## Wicklow County Council

RE: Referral Ref. ABP 320327-24

I refer to your letter of the 06/08/24 in relation to the above mentioned Referral. The Planning Authority considers that its reasons and considerations in relation to the submitted S5 Declaration Request are fully set out in its planning report and Declaration previously forwarded to the Board. However, the Planning Authority would like, in the interests of clarification, to comment on the submitted Referral as follows.

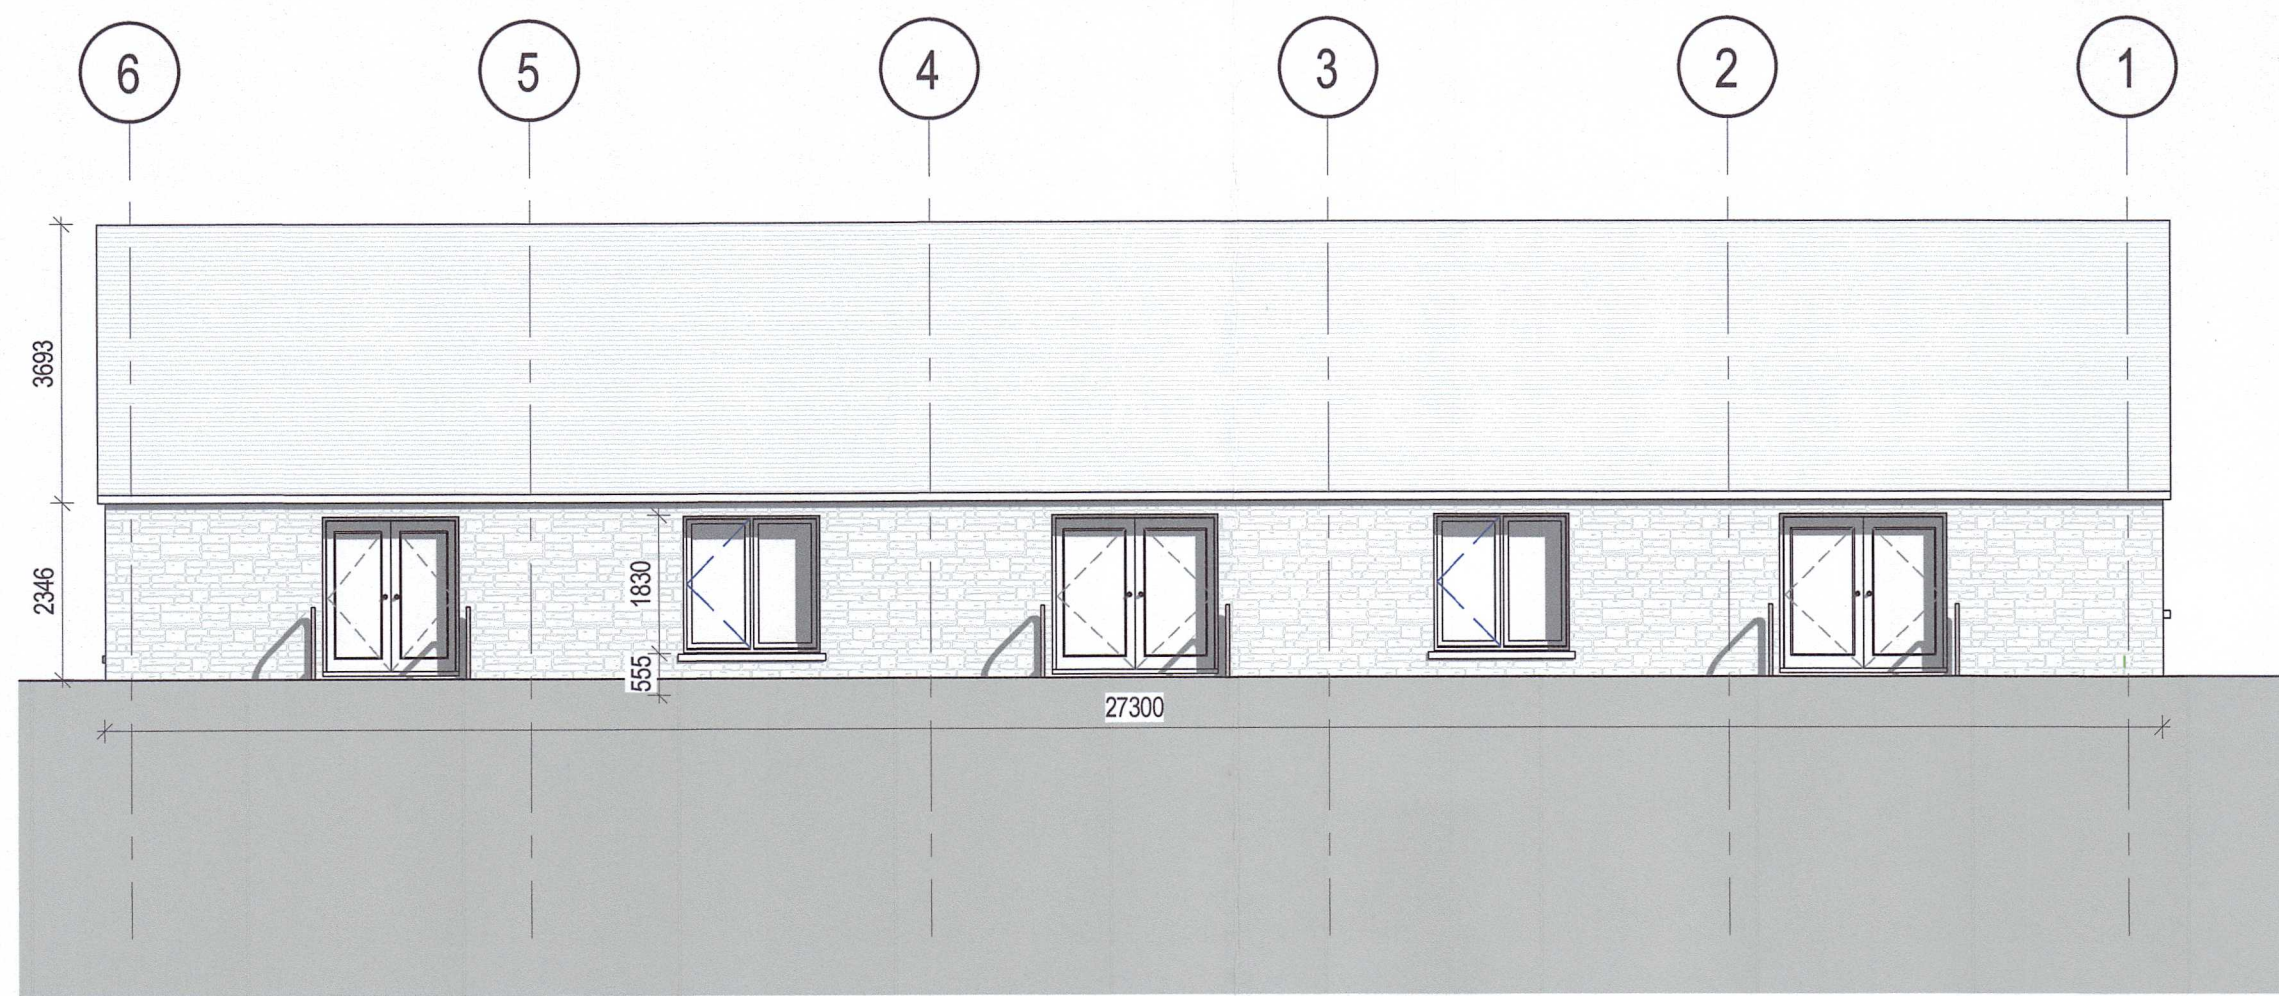
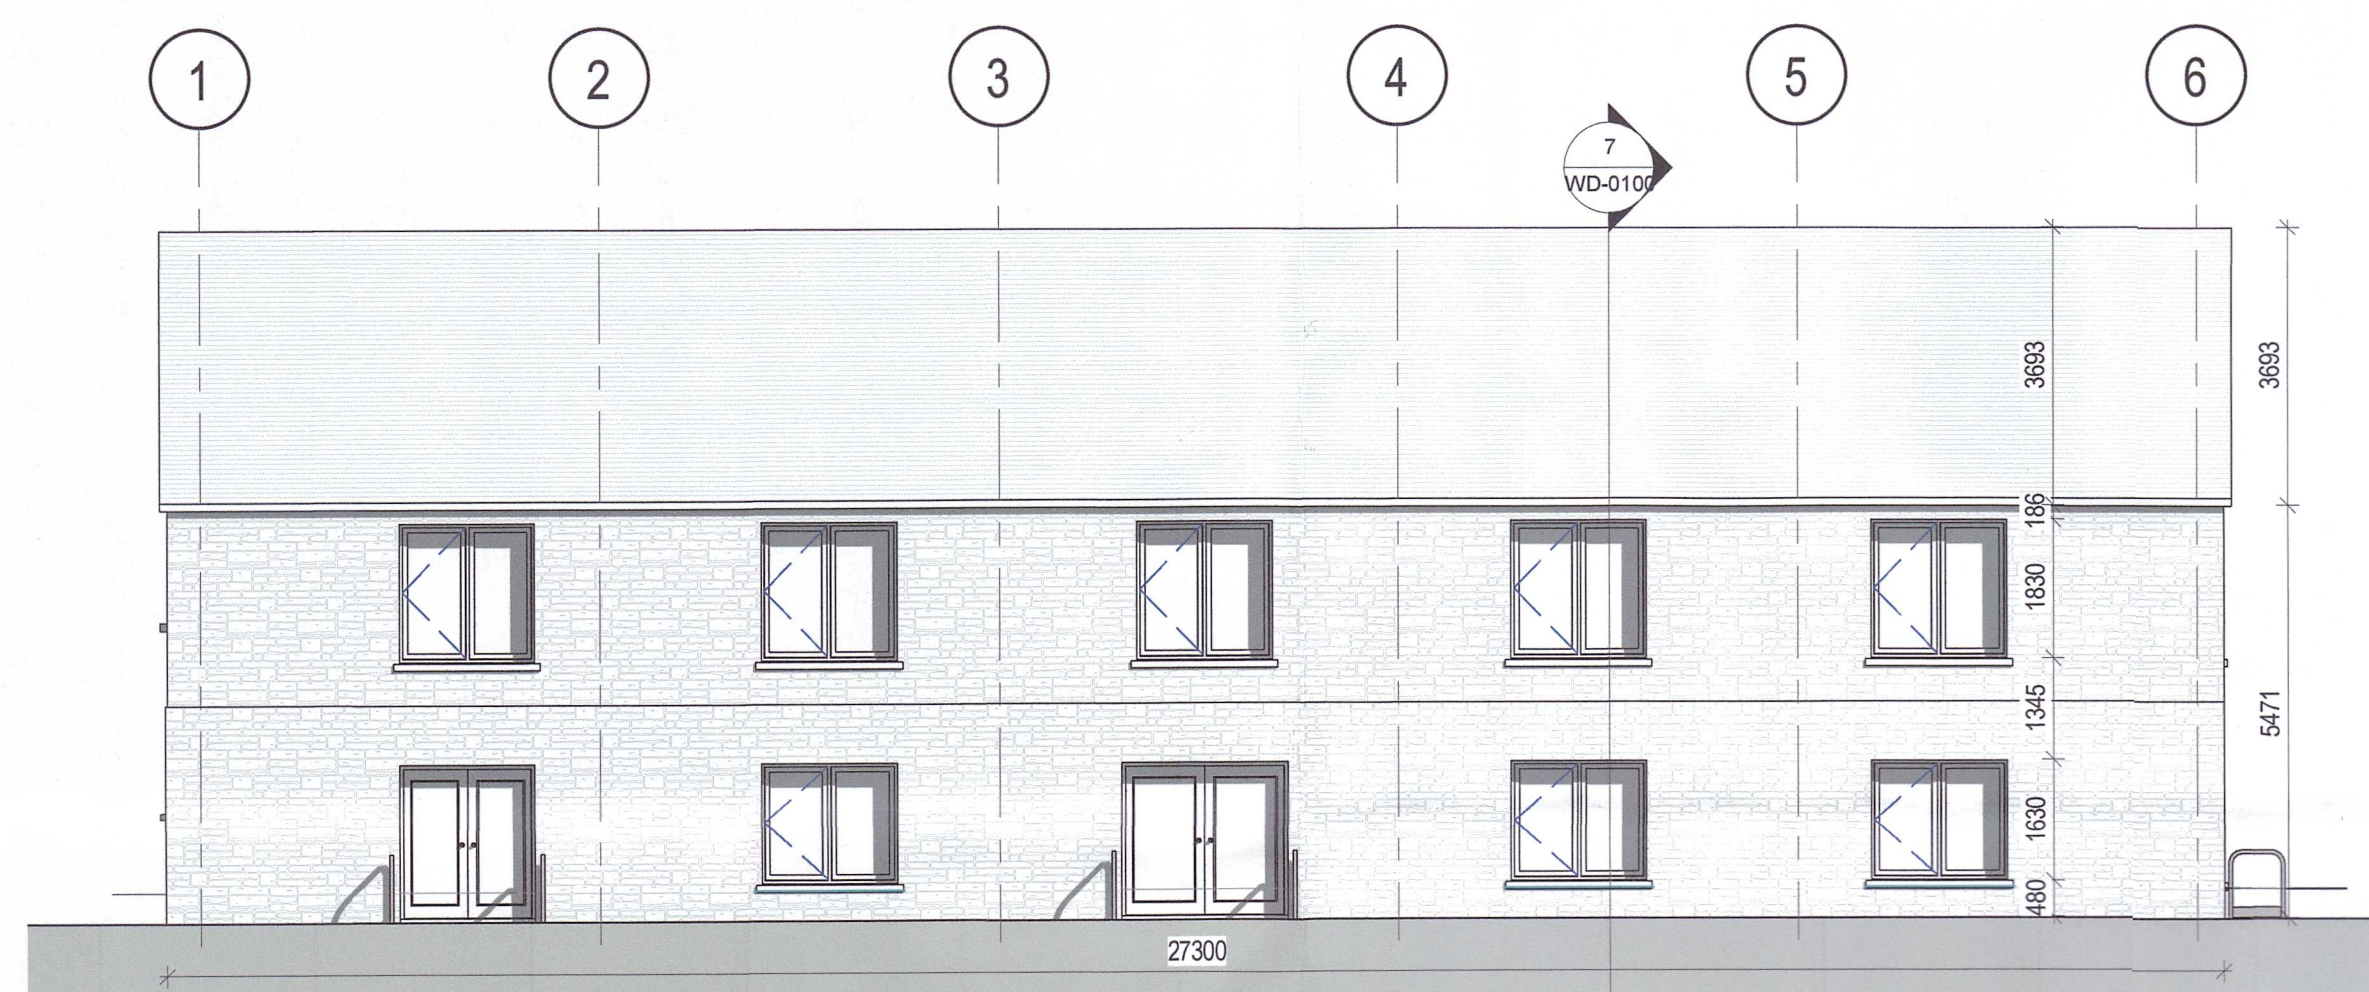
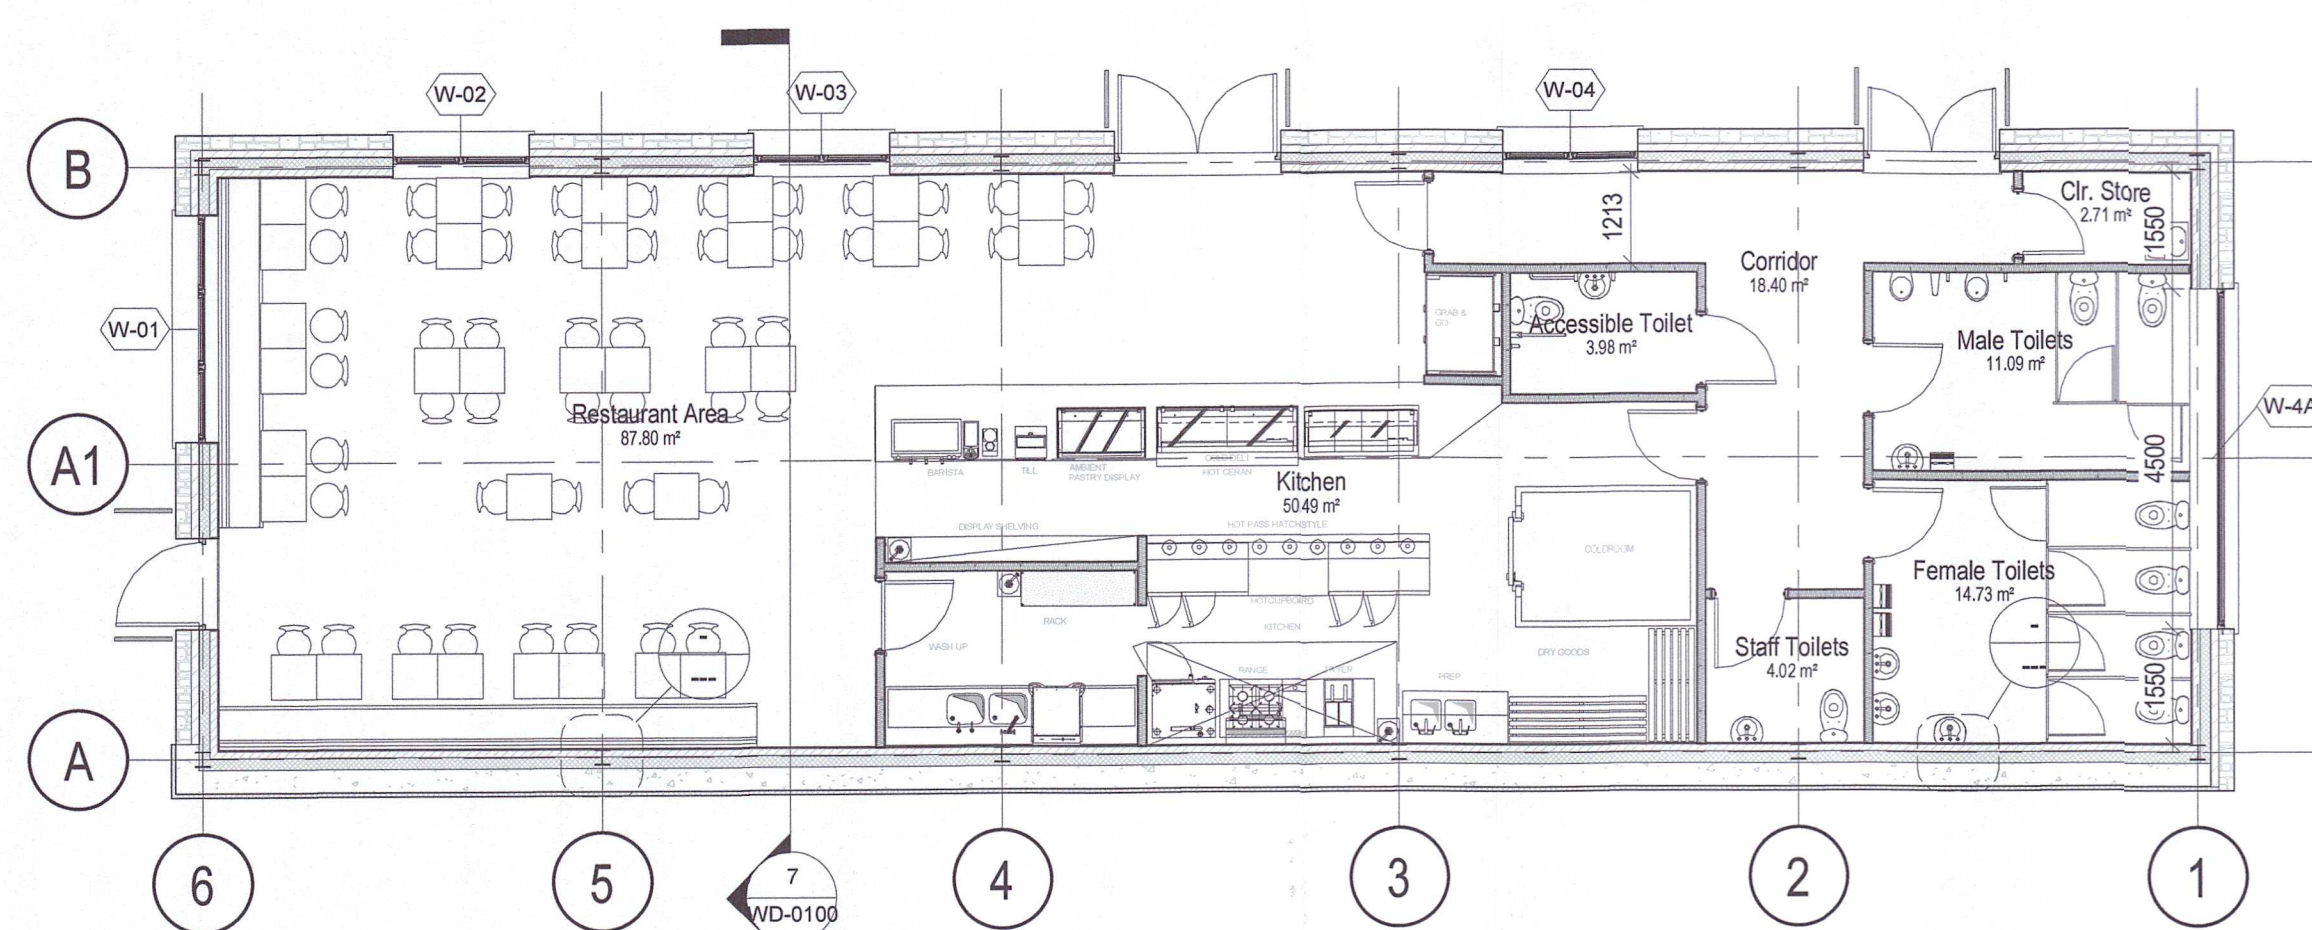
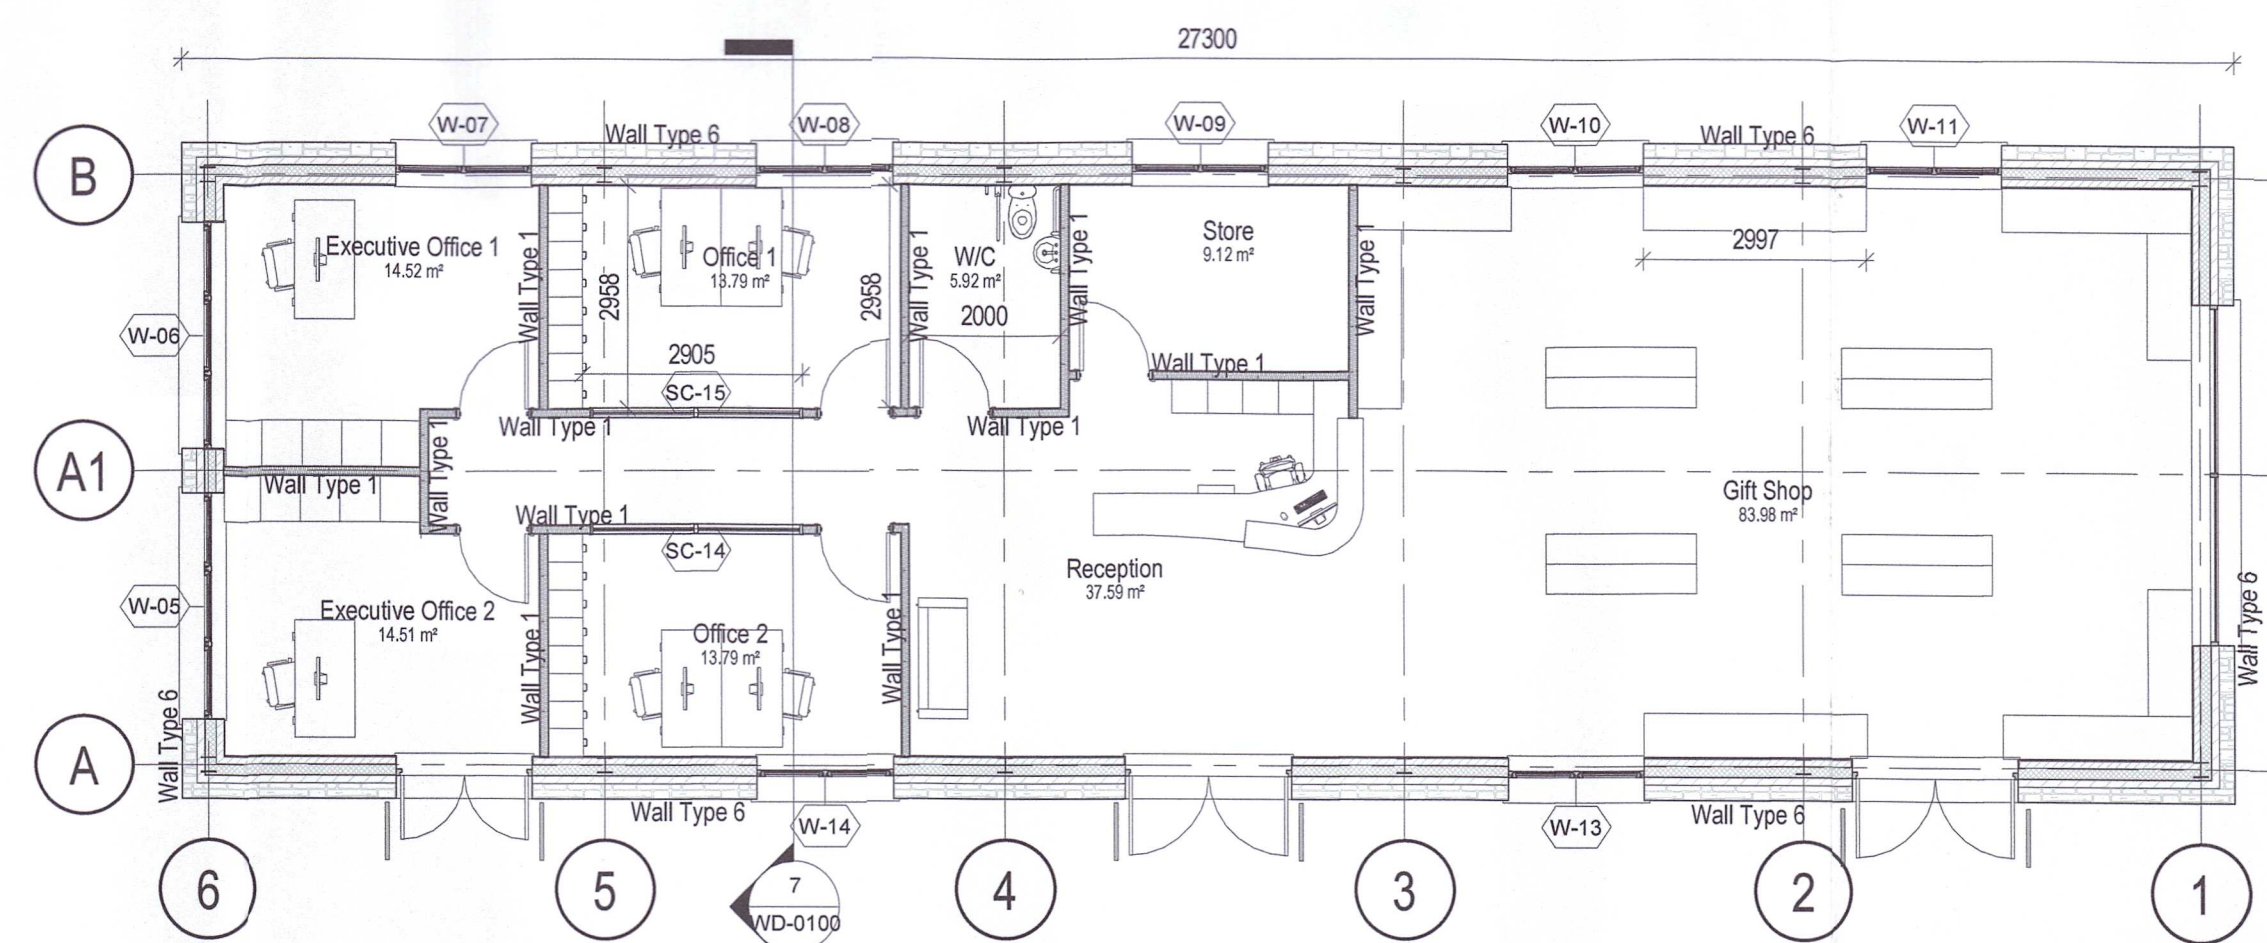
The Planning Authority, as it is entitled to do, determined that Structure No. 10 was significantly altered such that it was now inconsistent with the character of the original structure. There is no requirement to assess what the perspective of 03<sup>rd</sup> Parties from the public domain would be.

It also determined that the significant alterations did not come within the scope of S4 (1) (h).
